### Application for removal or variation of a condition following grant of planning permission.

Development: Erection of a first-floor front/side extension, two-storey rear extension, Raising the ridge of the main roof, installation of roof lights and erection of front porch.

Reference number: 15480/APP/2023/1687 Date of decision (DD/MM/YYYY): 22/08/2024 (date must be pre-application submission)

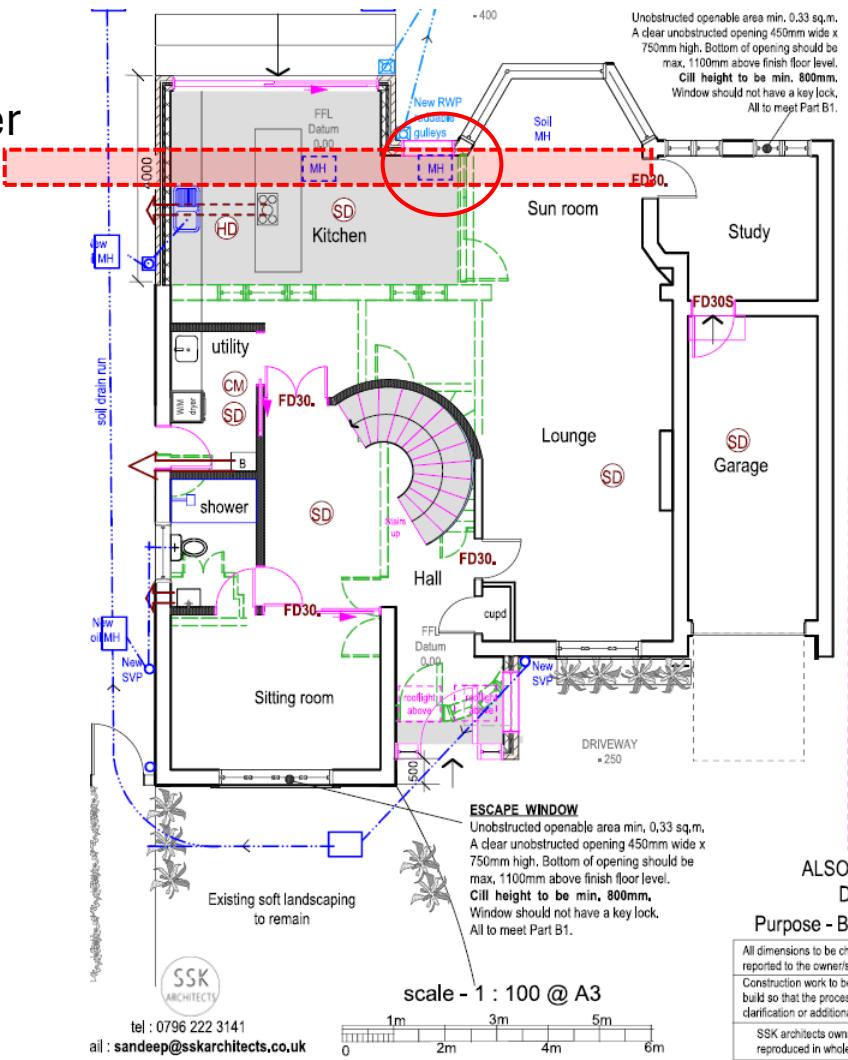
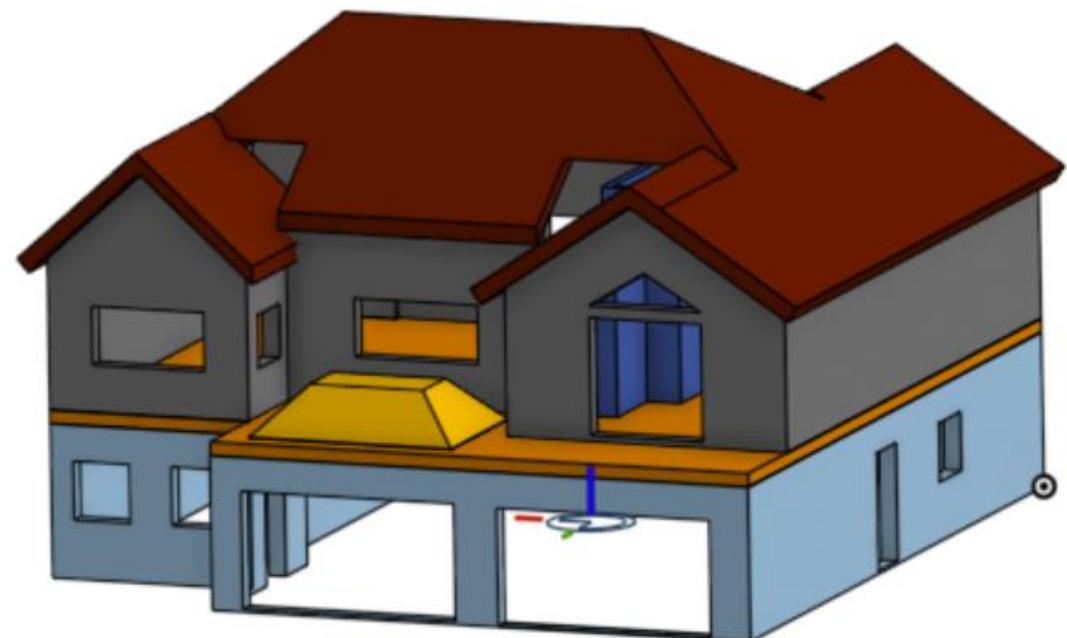
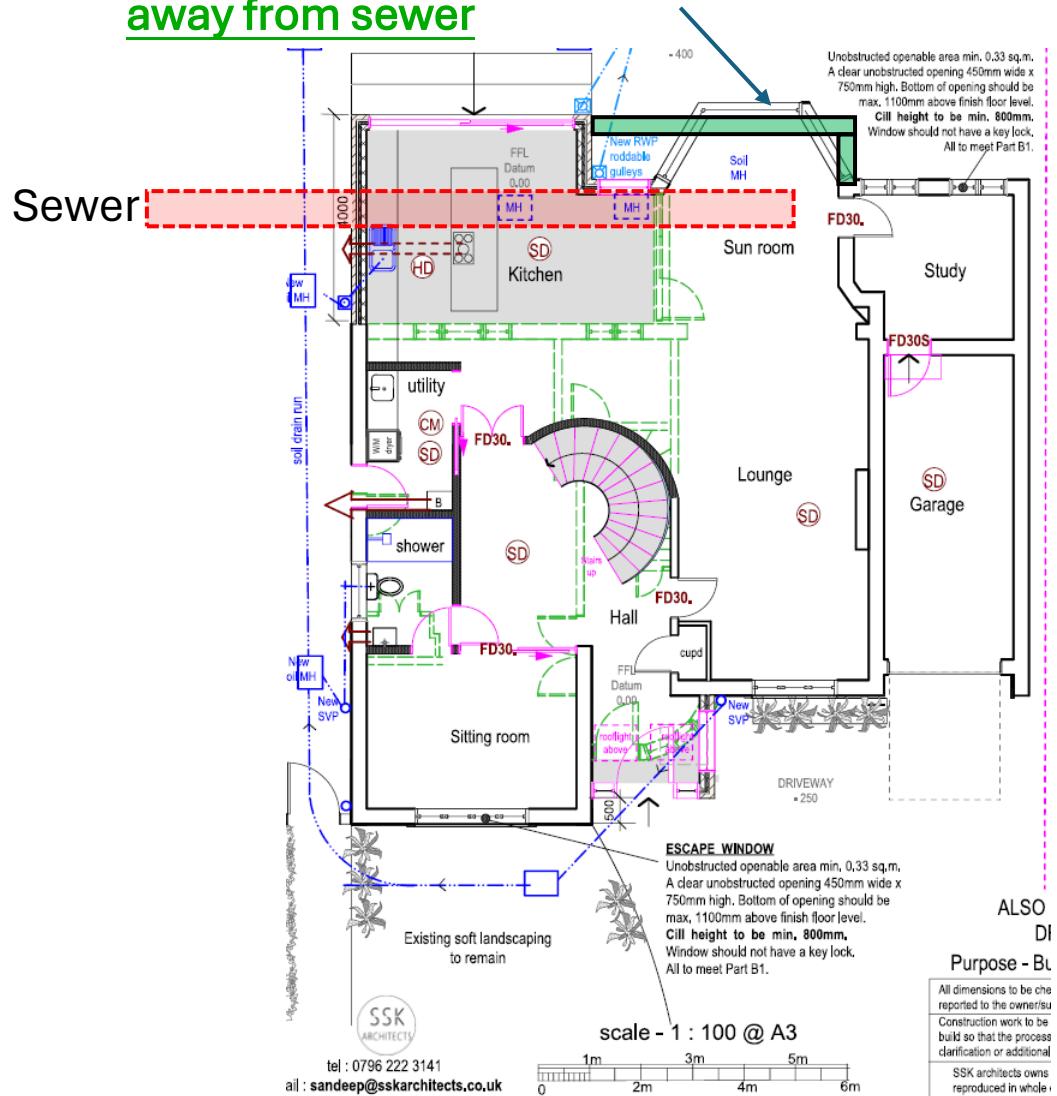
The existing plans require a foundation to be placed where the sewer is located. Furthermore, the builder informed us that it would be very difficult to seal the existing conservatory onto the building wall most likely causing future problems.

We would like to request that the foundation and conservatory wall can be placed onto the same line as the proposed rear extension (see attached drawing at end of form) so that foundations will not interfere with the sewer and to make sealing of the conservatory onto the remainder of the building more reliable.
